**From:** Central Permitting Mailbox  
**Sent:** Monday, July 28, 2025 10:14 AM  
**To:** Carter Smith  
**Subject:** RE: 422 hillandale Dr plan

RESIDENTIAL  
BUILDING

Main Level Layout

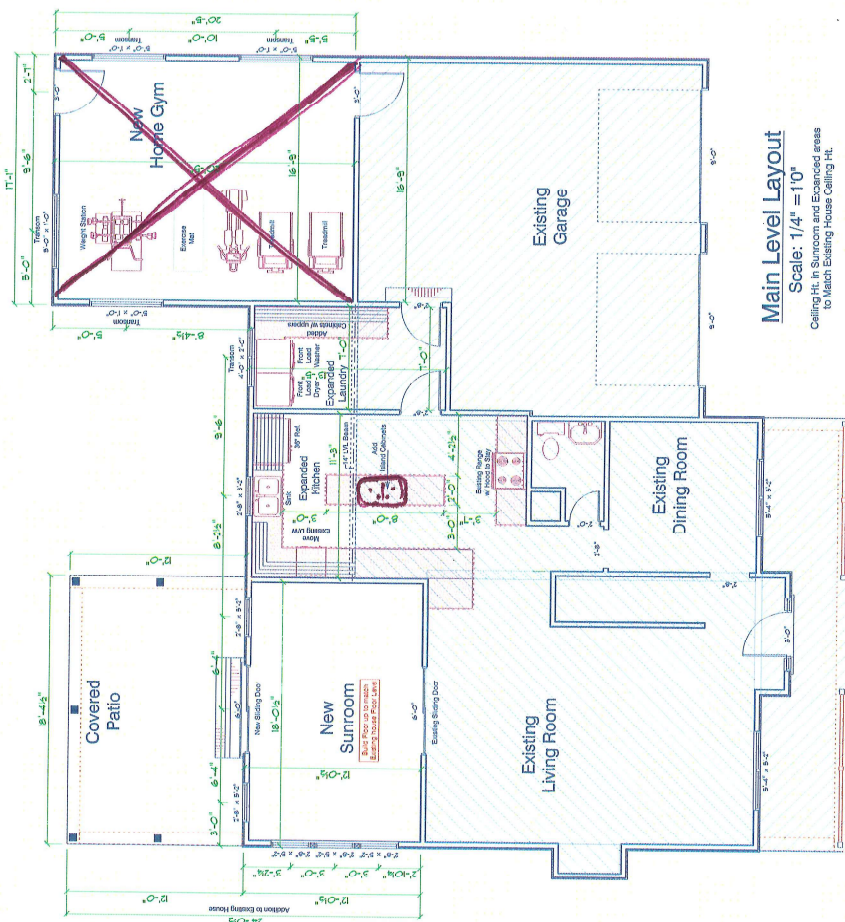
Provide a complete set of construction drawings for addition from footings through roof.

Only a floor plan was submitted.

If enclosing existing patio, provide code complaint footing design for roof support. Roof may not be supported on 4 inch slab
